Re: Morrison Supply 301 Indiana SE_{cc}
Request for Permanent C.O. – Acceptable
Engineer's Stamp dated: 08-08-13 (K-18/D021)
Certification dated: 4-30-14

**Re: Morrison Supply
Request for Permanent C.O. – Not acceptable
Engineer's Stamp dated: 08-08-13 (K-18/D021)
Certification dated: 12-12-13**

**Re: Morrison Supply, Grading and Drainage Plan
Engineer's Stamp Date 8-8-13 (K18D021)**

RE: **Morrison Supply – Warehouse, 301 Indiana SE**
Grading & Drainage Plan for Building Permit
Tract 6-A-1, Block 14, Fairgrounds Addition

GRADING & DRAINAGE PLAN

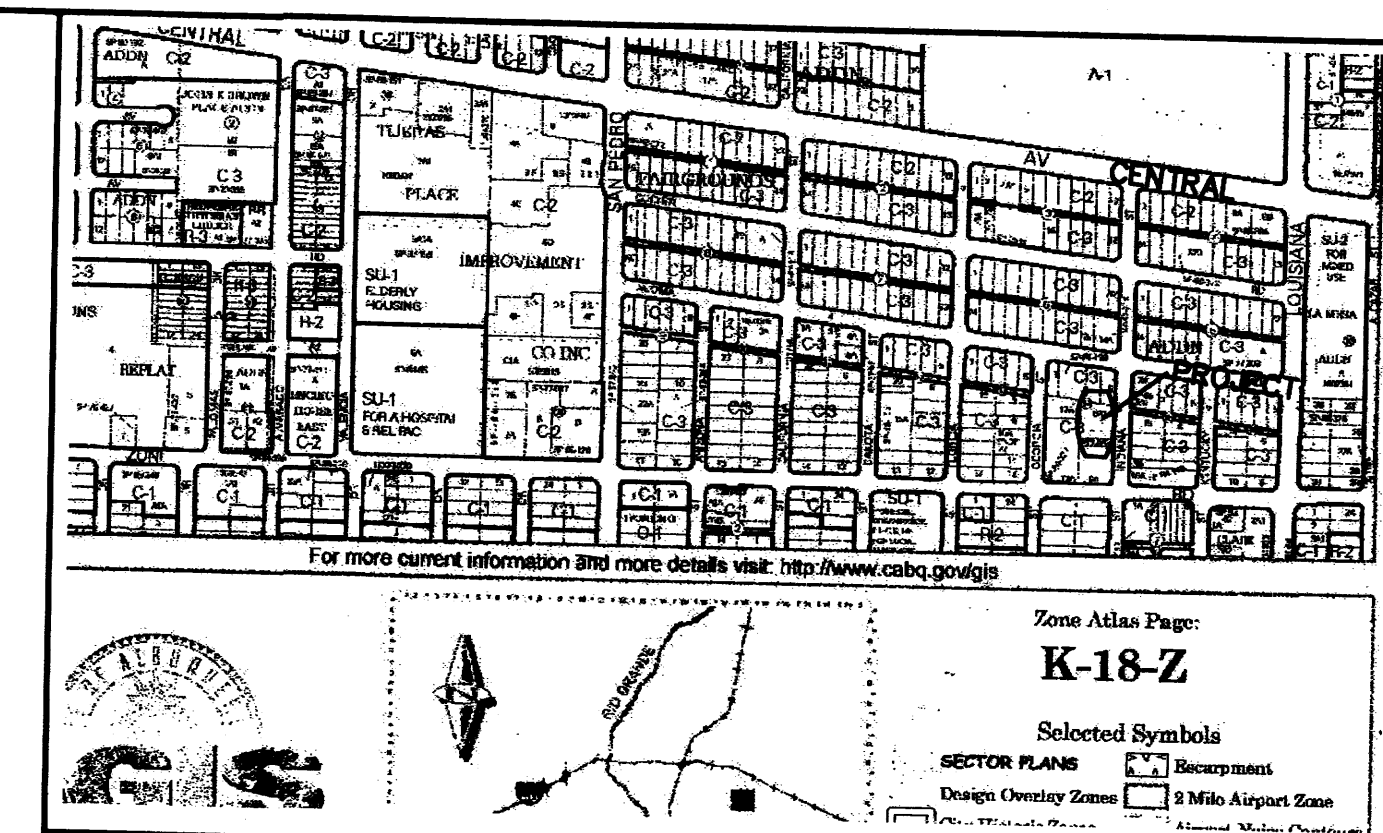
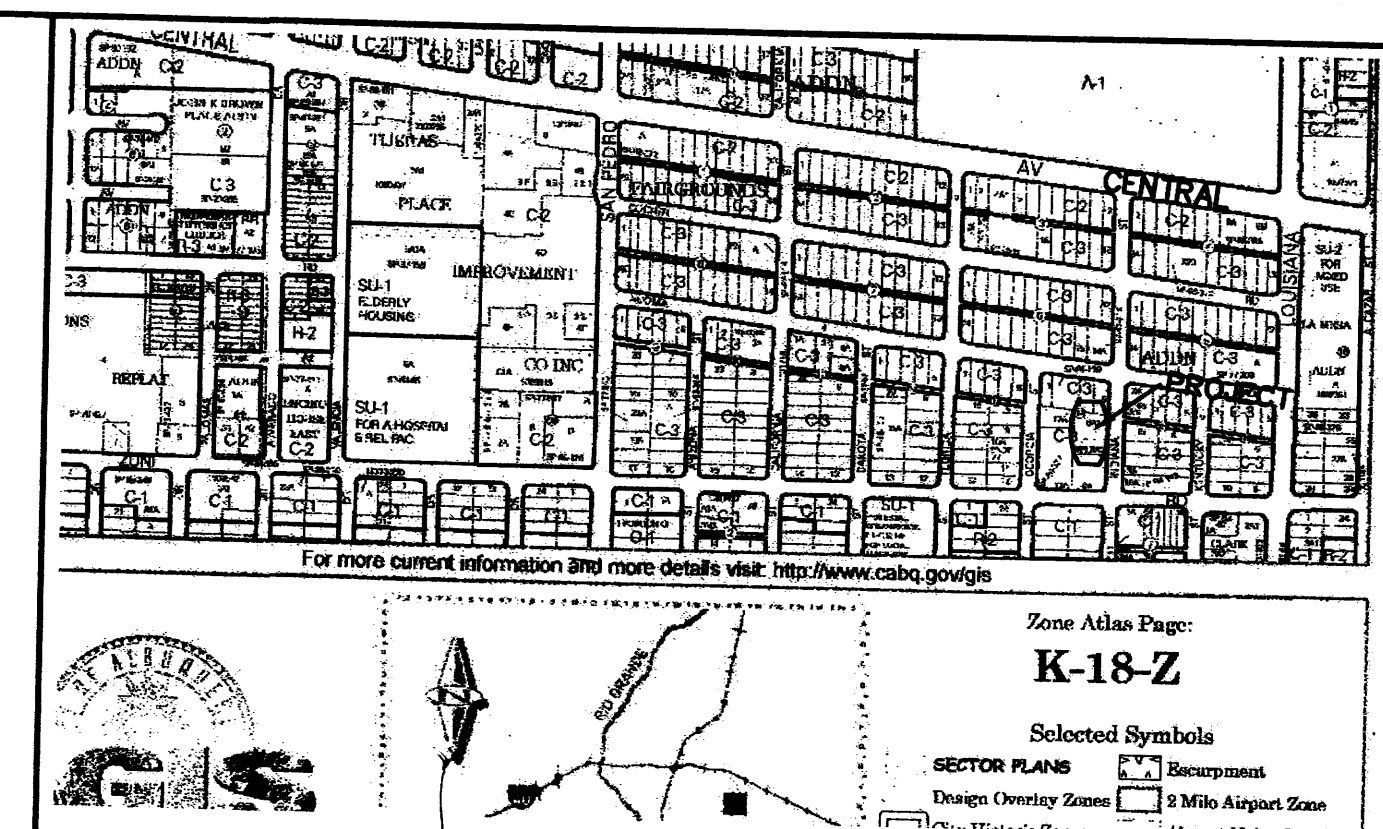
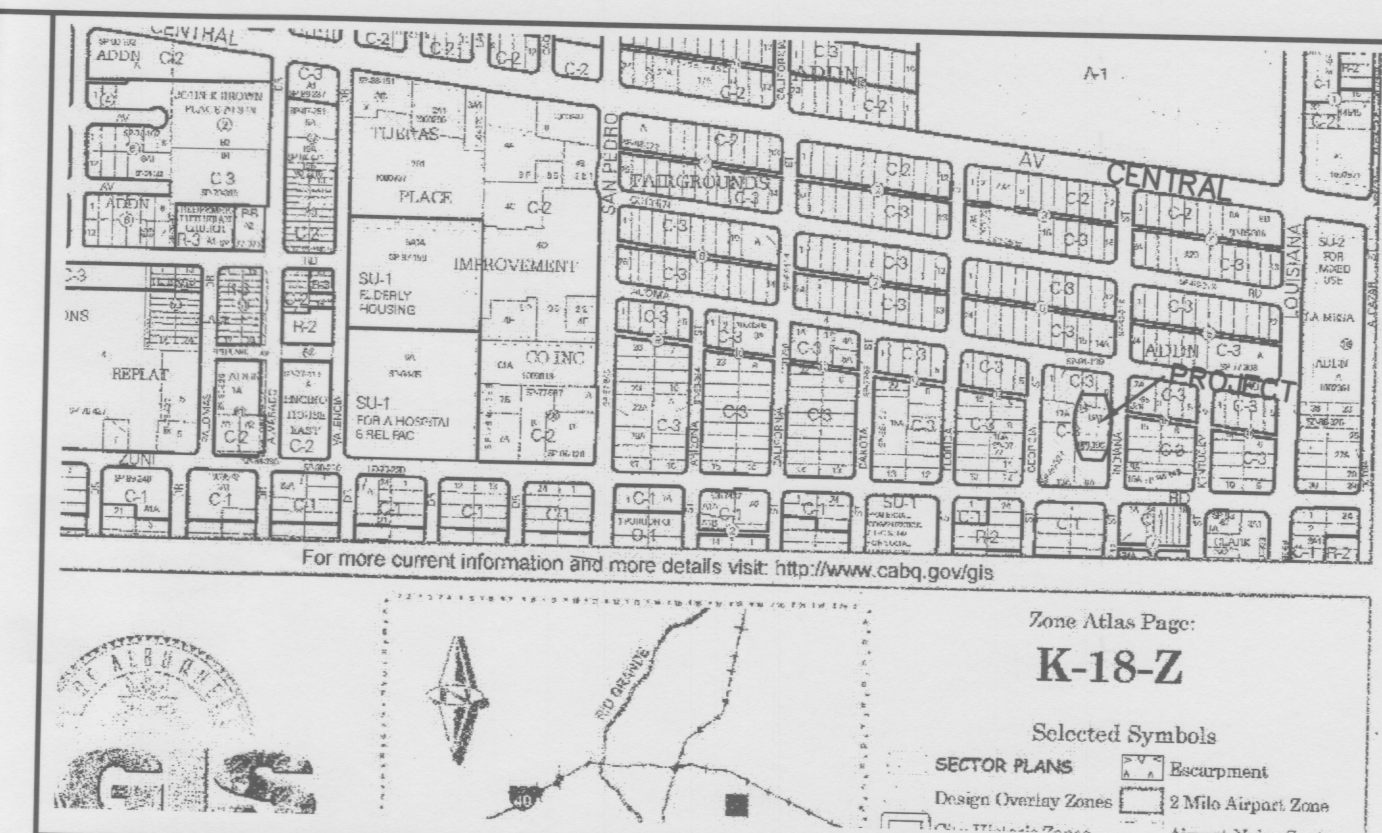
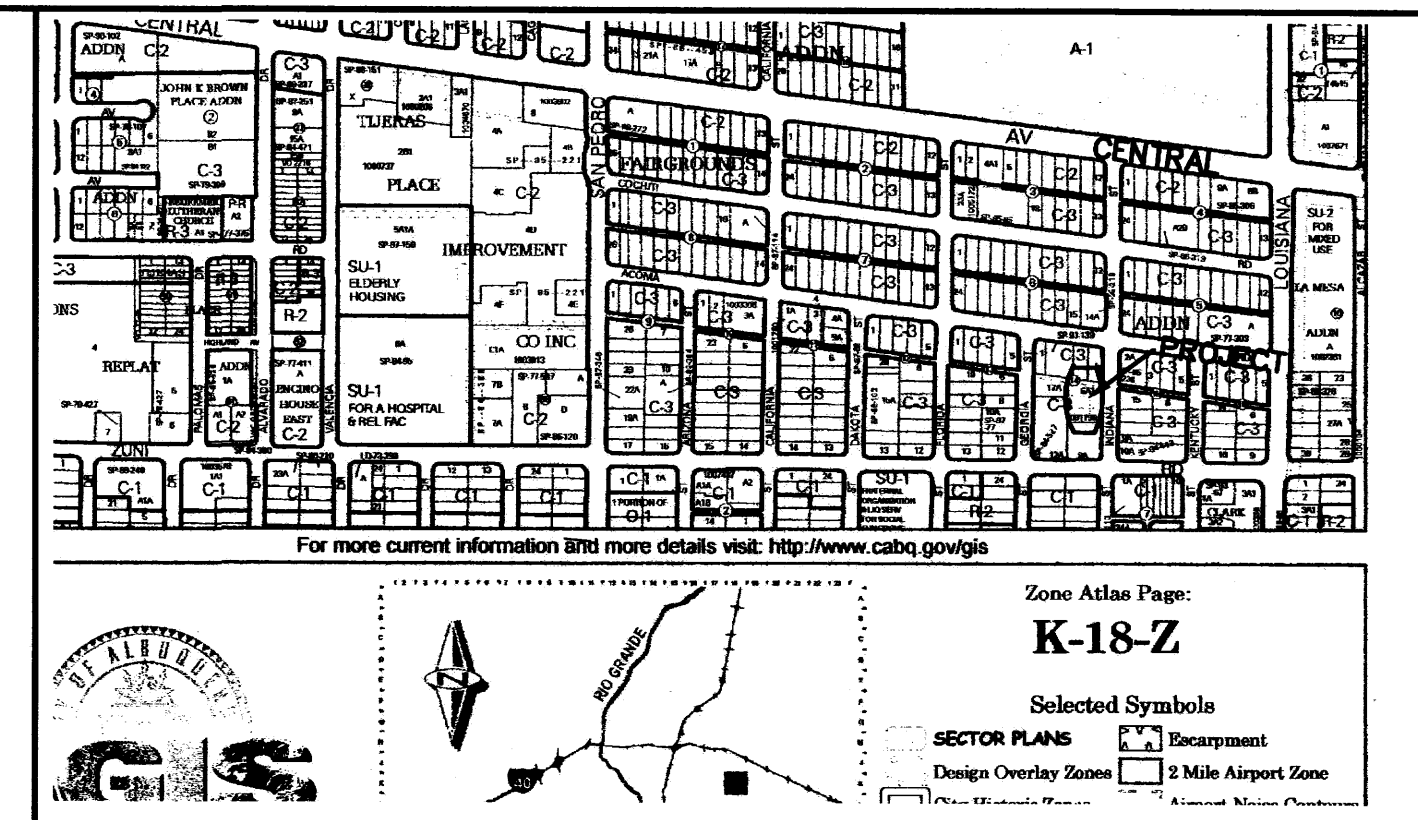
1. The drainage plan does not recognize off-site flows from the NE corner of Lot 9-A. Grades provided indicate roughly 0.10 acre of that lot discharging to this site.

2. This plan shows a loading bay / ramp, west of the building, which acts as a sump for runoff from the southern 25% of the site paving. Provide pump calculations to show that flows intercepted at this point are conveyed to the harvesting pond, as shown, and are not allowed to overflow to Tract 12A at elev. 9.50.

3. Is the 8" force main intended to run under the building pad? The Referenced Mech. Plan was not provided with this submittal. (7/31 revision to 4" line around building appears ok)

4. Provide sizing of the sump pump(s) to discharge to the eastern pond. (Your 7/31/13 proposal of a Zoeller 268 Pump appears undersized.) Provide calculations of runoff entering the sump in the design storm, and size pump(s) and pipe accordingly.

5. Provide documentation of the Construction Easement and Access Easement necessary to support the ramp construction and operation on Tract 12A.
6. Clarify the point and direction of overflow from the water harvesting pond, on the east edge of the site. Will flows exist through the old alley entrance, northeasterly to Indiana Street, or will they drain westerly in the vacated alley corridor?

7. Sub-basin boundaries would be helpful in quantifying proposed run-off.

8. This plan has a note to "ENSURE 0.3' INVERTED CROWN AND POSITIVE DRNG, TO GEORGIA" in the Private Surface Drainage Easement (Vacated Alley) along the north edge of Lot 17-A. Provide survey to verify this, or contours and additional spot elevations for grading of the drainage corridor. In my 7/30/13 field visit, I observed the old alley corridor to be heavily obstructed by material/equipment storage, potentially causing a mid-block diversion of runoff flows to private property on the north side of the easement. This plan and construction must confirm the outfall capacity to Georgia and/or Indiana St.

GRADING & DRAINAGE PLAN

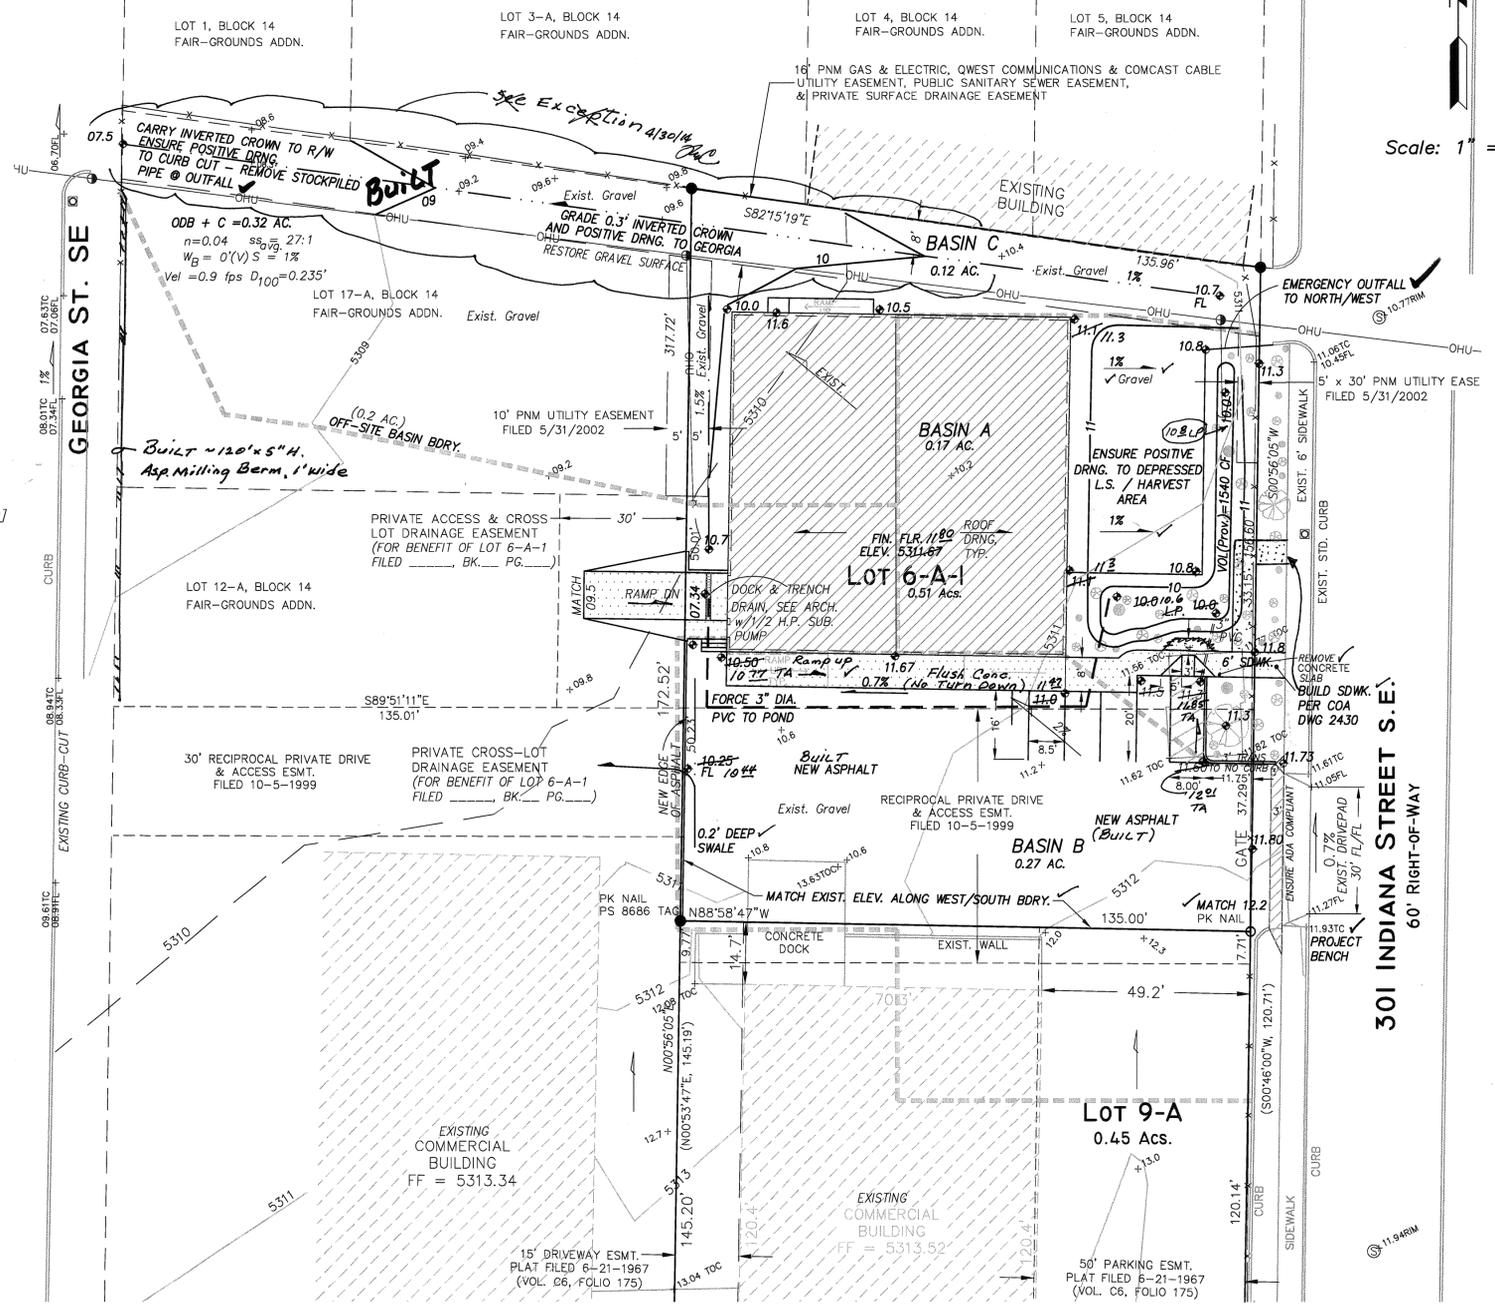
Based on the Certification received 12/12/2013, the site is not acceptable for release of Certificate of Occupancy by Hydrology. The exception for the alley not being graded is appreciated and duly noted. However, because the alley was not graded to ensure positive drainage, flows from the roof and the alley itself are draining toward a building and property to the north, adversely impacting this area.

There are also concerns with the flows to the west of the new building leaving the site over the public sidewalk on Georgia St., leaving debris on the sidewalk adversely affecting the public. These flows should be exiting either the alleyway driveway on Georgia St. or the entry/exit driveway to the south of the alleyway on Georgia St.
